**Reference: Planning Application: AW/353/14/PL**  
**Demolition of No 11 Marquis Way and to replace with a new residence proposed by**  
**Mr P Greenwood**

**Planning Reference Number AW/353/14/PL**

**RE: Planning application AW/353/14/PL**

project: 11 Marquis Way - Aldwick			
drawing title: Proposed Site Plan			
drawing status: Planning Application			
date: 09 - 12 - 2014	scale at relevant drawing size 1 : 50 (A1) or 1 : 100 (A3)	no: JW131105 - PL10	rev.: -

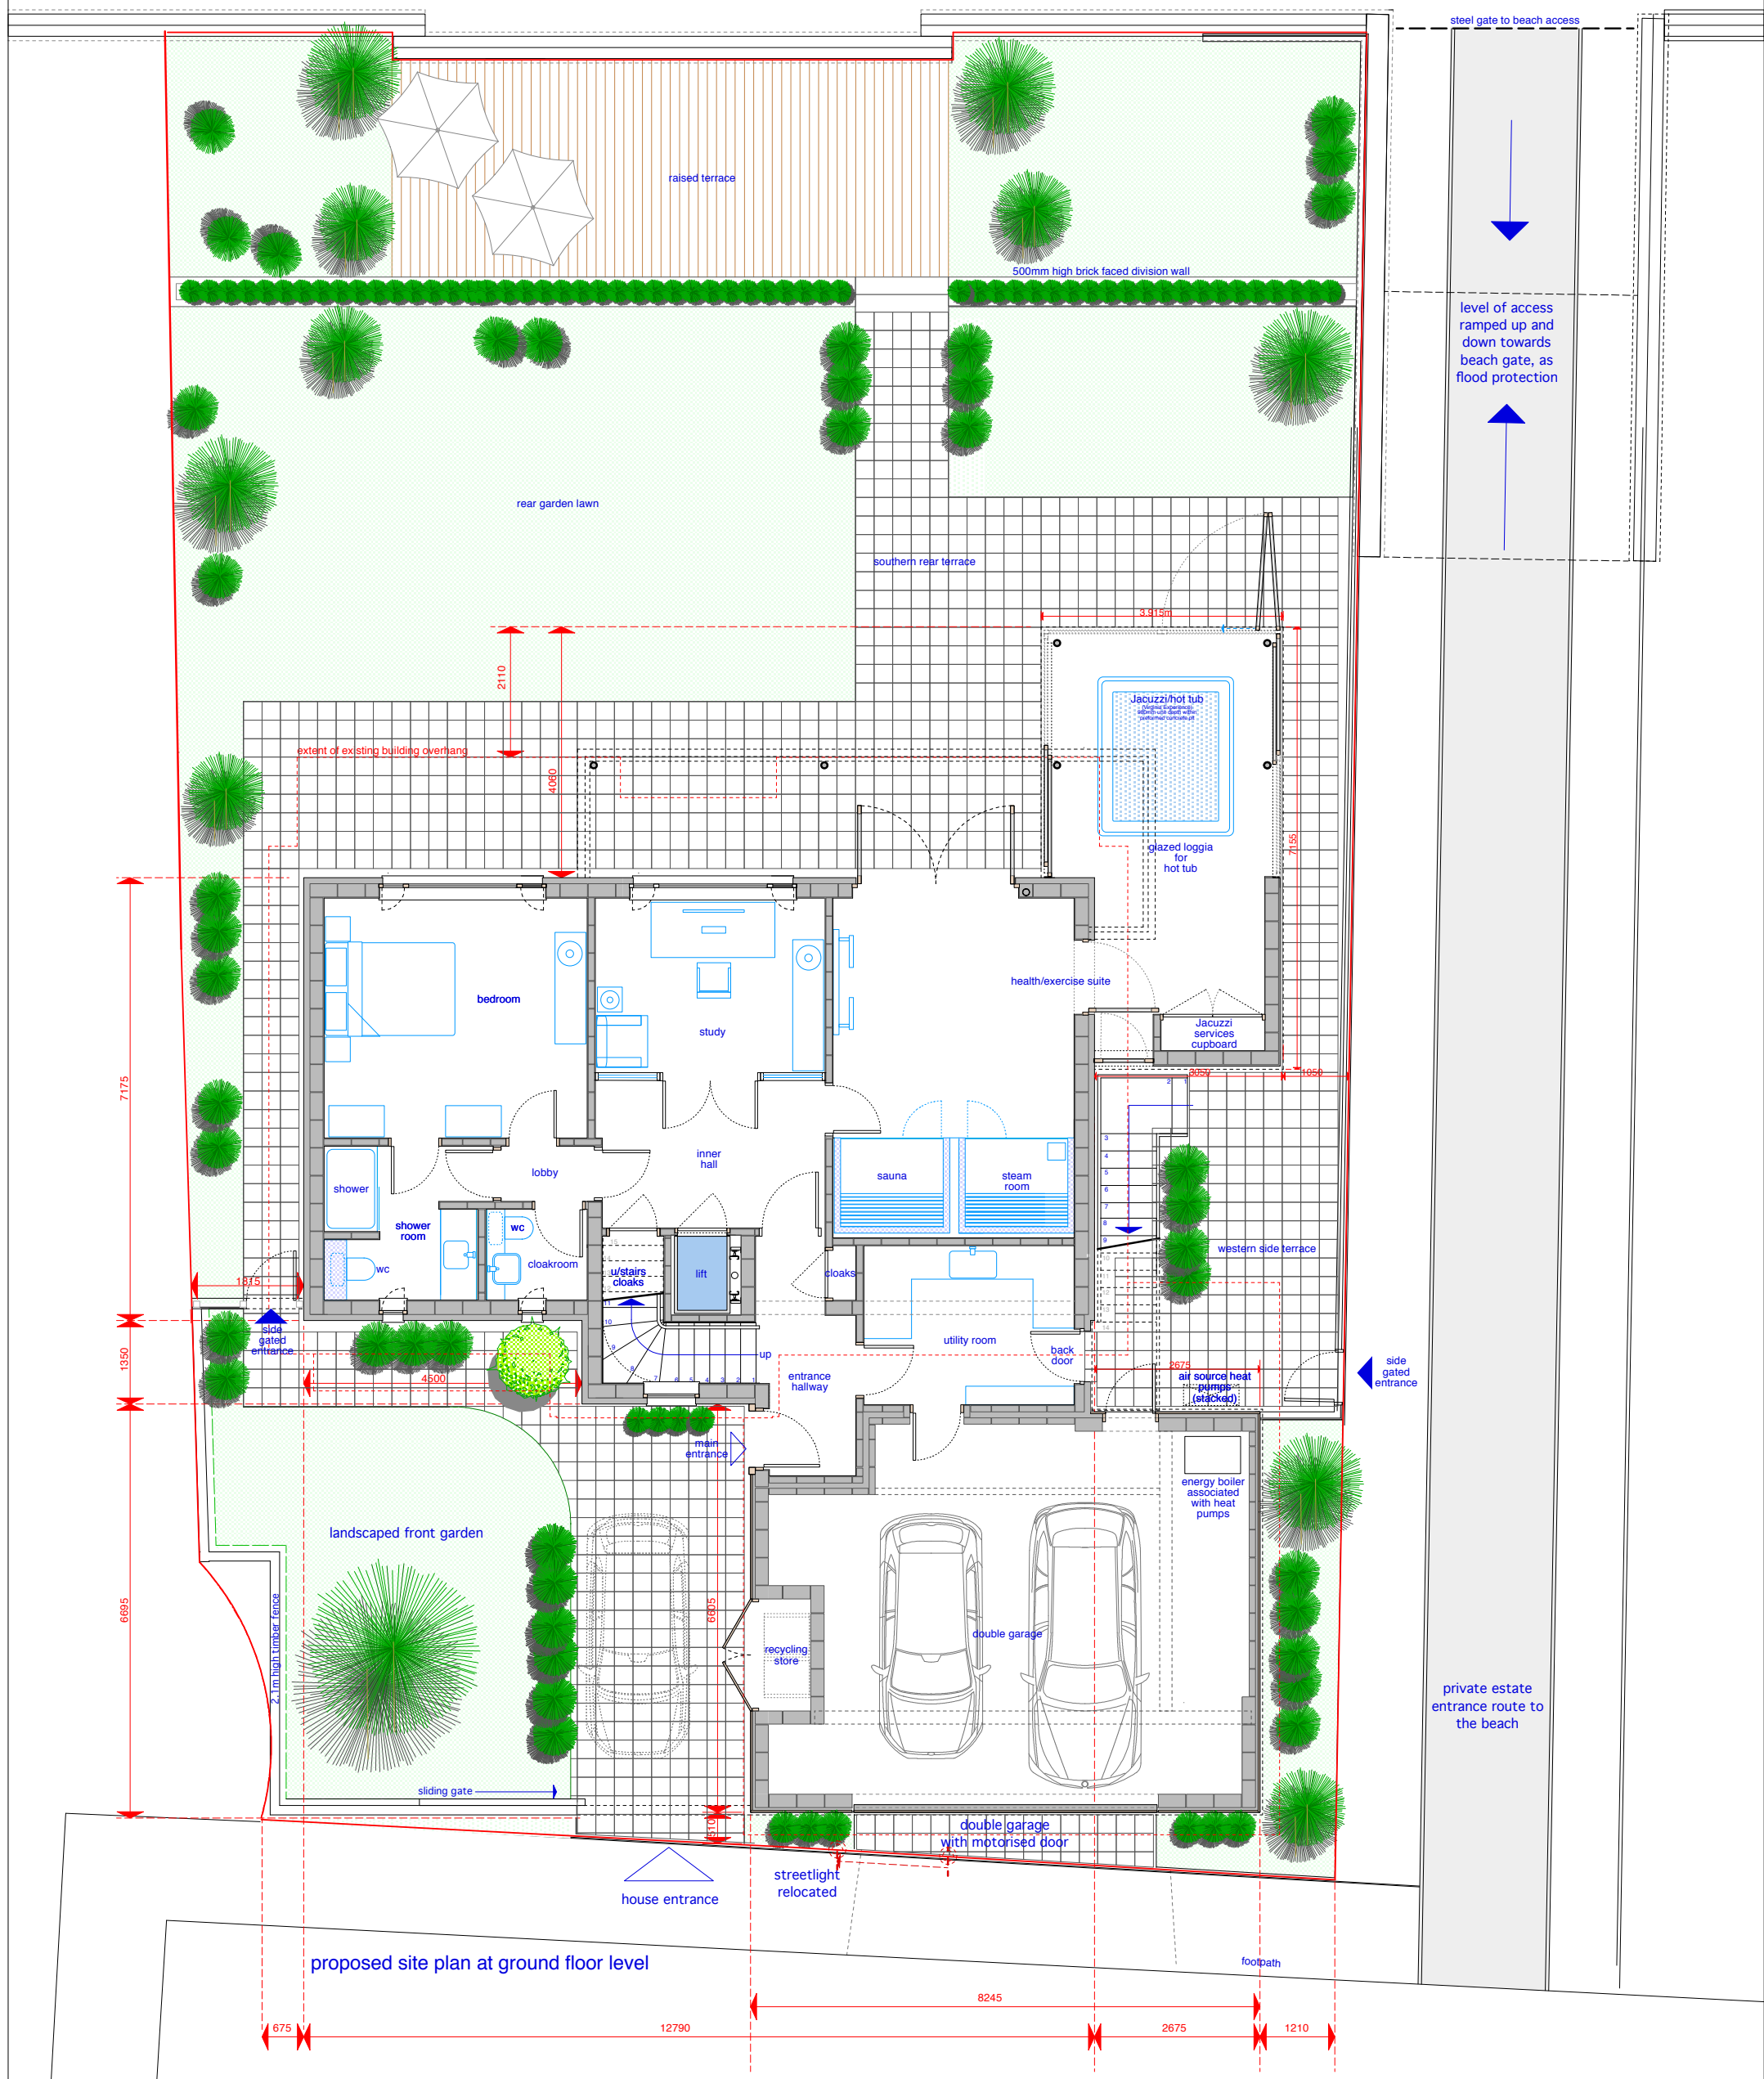
- **Design and Appearance.** The design and resulting appearance of a flat roofed, rendered house with extensive first floor balconies will differ from all other properties which are constructed of brick with a pitch roof of either slate or concrete tile. The plans show that the south and west facing elevations extended beyond the existing building line. The south facing building line was enforced when planning approval was granted for the extension to No.15

**Design and Appearance.** The design of a flat roofed, rendered house with extensive first floor balconies is out of character from all other properties which are constructed of brick with a pitch roof of either slate or concrete tile. The plans show that the south and west facing elevations extended beyond the existing building line. The south facing building line was enforced when planning approval was granted for the extension to No.15

project:	11 Marquis Way - Aldwick		
drawing title:	Existing and Proposed Parking Plans		
drawing status:	Planning Application		
date:	09 - 12 - 2014	scale at relevant drawing size	1 : 100 (A1) or 1 : 200 (A3)
no:	JW131105 - PL16	rev:	-

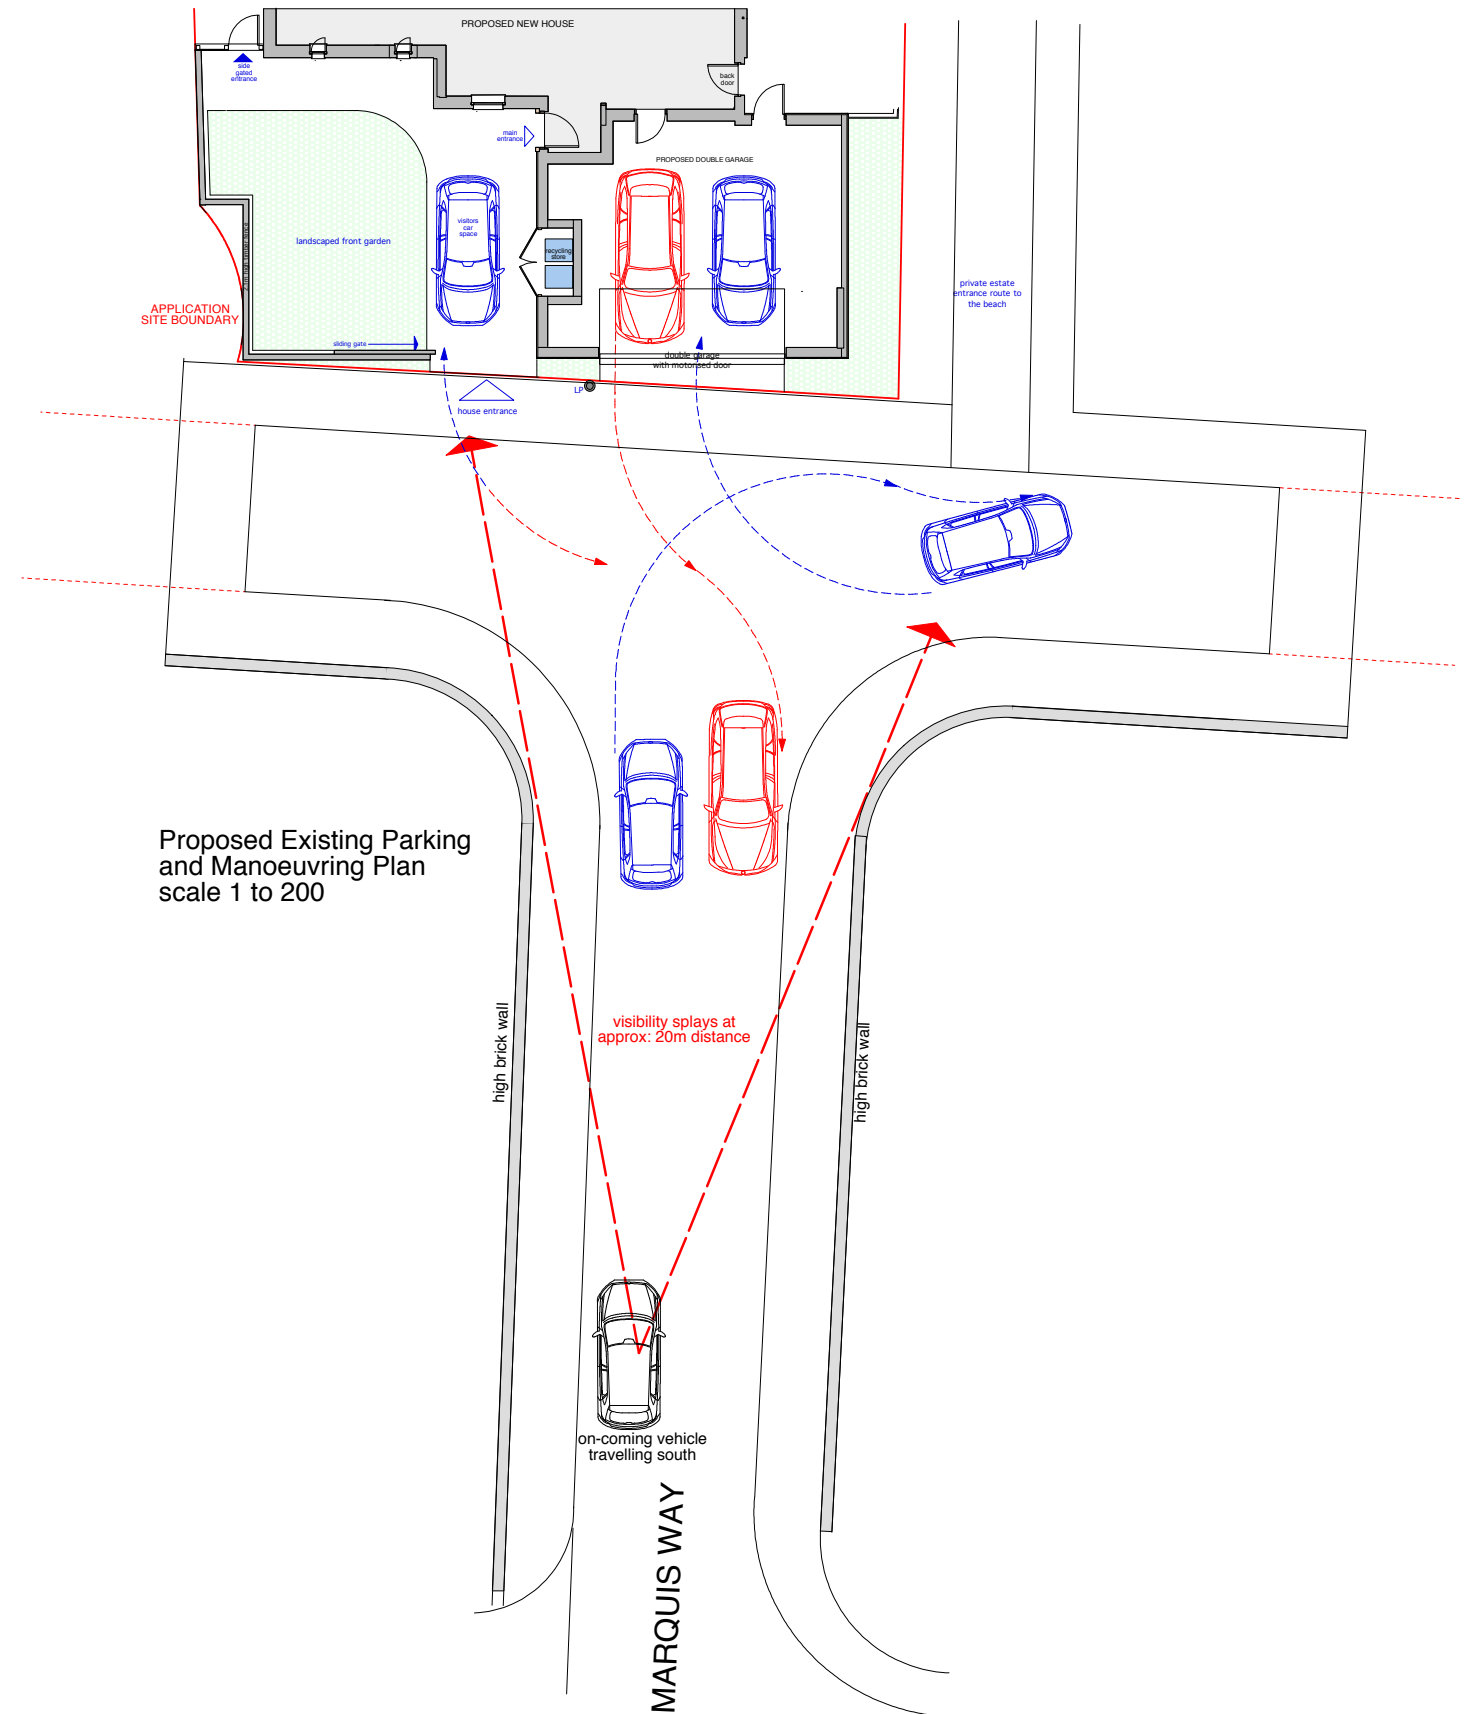
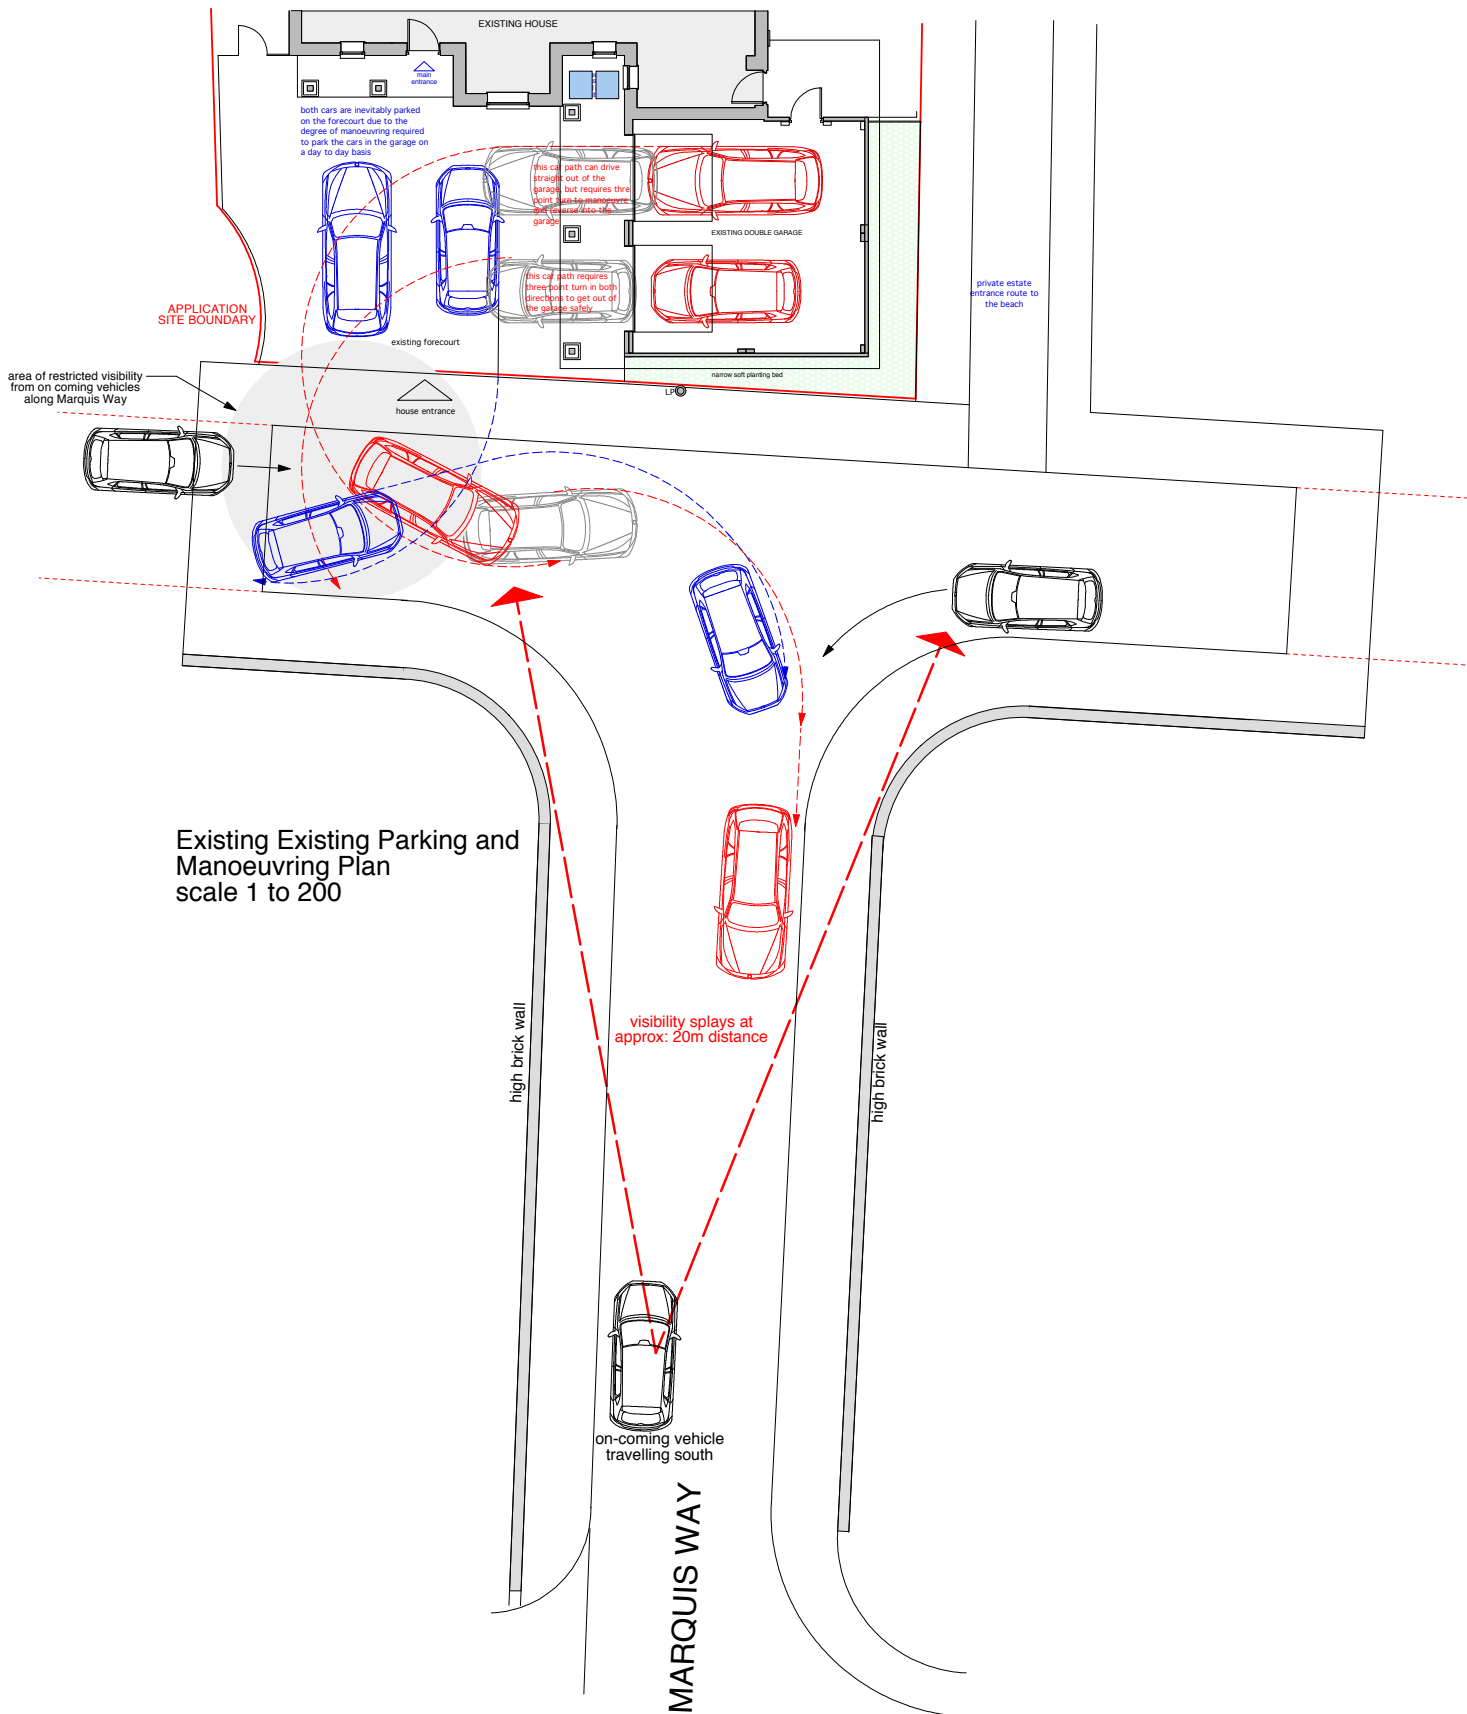
There is a safety issue in that the proposed garage door will open directly onto the pavement endangering pedestrians and having a restricted view of traffic.

The design shows that cars will drive straight out of the garage on to the road raising a safety issue for 5 other residents using this section of the estate road.
- **Planning History.** Previous extensions to Marquis Way properties have, according to planning approval conditions, all had to "match in colour and texture those of the existing buildings" (AW/200/10). This proposal does not.
- **Privacy.** Several properties not currently overlooked in any meaningful way, will be as a result of a first and second floor north and west facing balcony.
- **Appearance.** The proposed design will have a major negative visual impact within the estate but also from the beach and from properties opposite the entrance to Marquis Way. In the case of the

The proposed planning shows access to the garage entering and exiting straight on to the road, which is a T-junction and could cause serious problems for people visiting No's 9, 10, 12,14, and 15. It will also be a danger to residents walking by.

project:	11 Marquis Way - Aldwick		
drawing title:	Proposed Sections A and B		
drawing status:	Planning Application		
date:	scale at relevant drawing size	no:	rev:
09 - 12 - 2014	1 : 50 (A1) or 1 : 100 (A3)	JW131105 - PL19	-

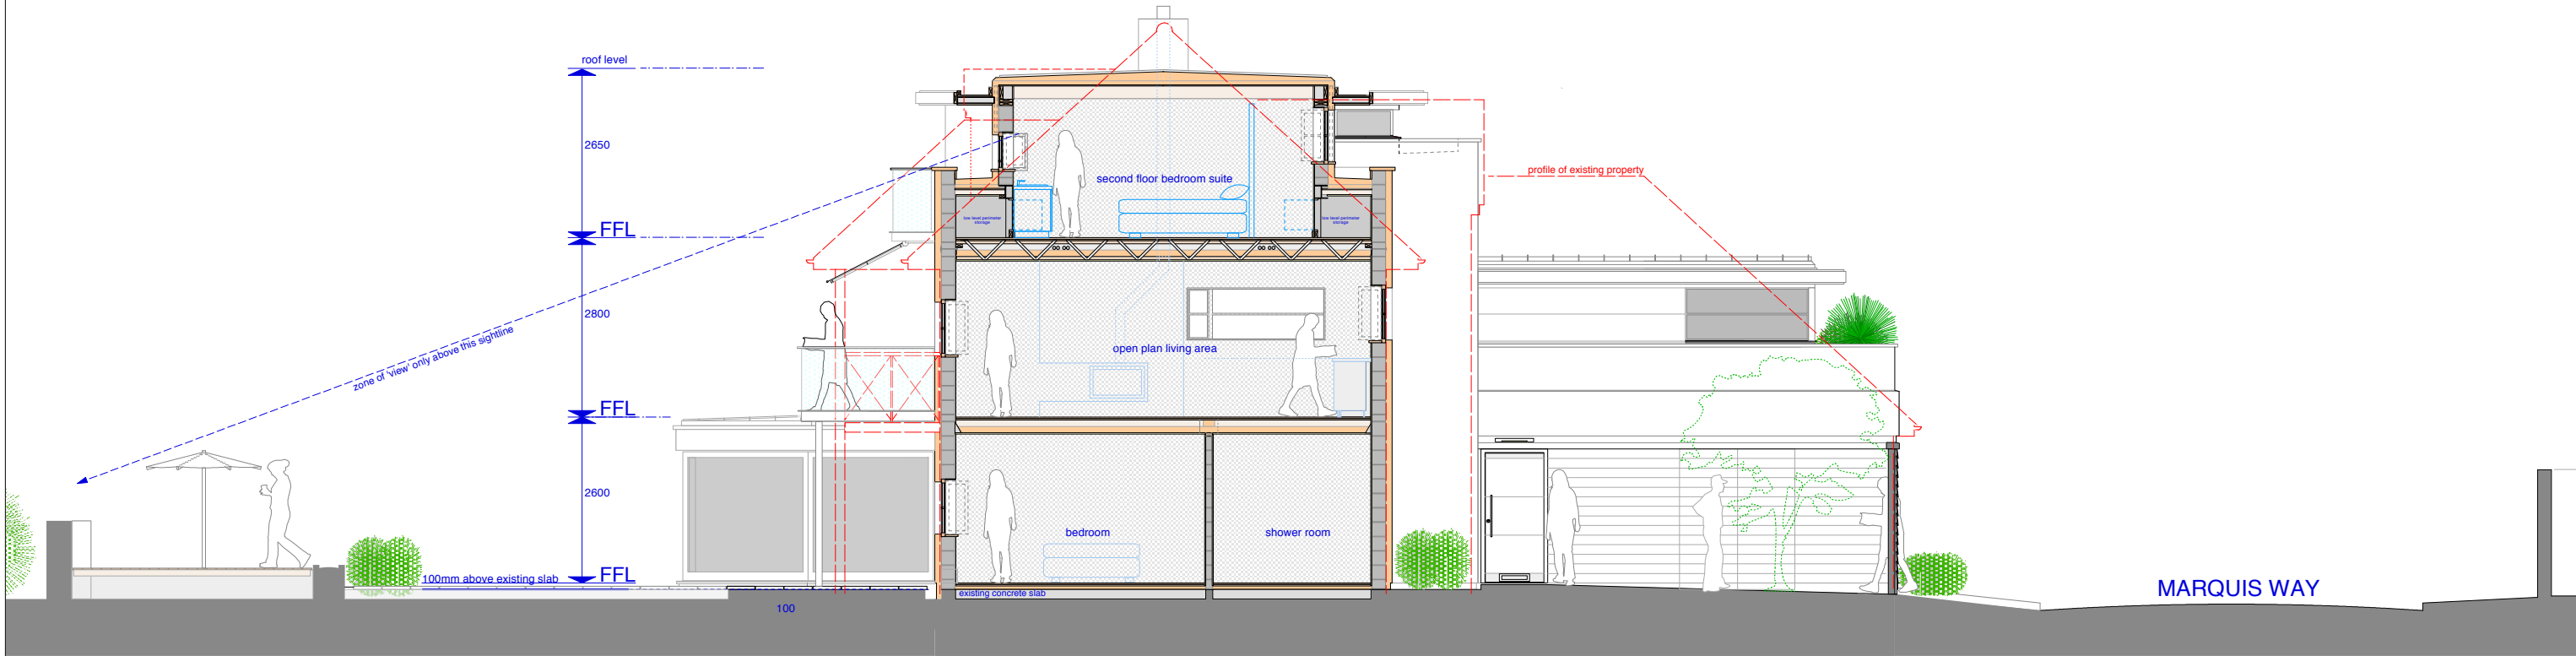
**Privacy.** A number of properties not currently overlooked will have the intrusion of the first and second floor, west and north facing balconies, with direct site in to their house and gardens.
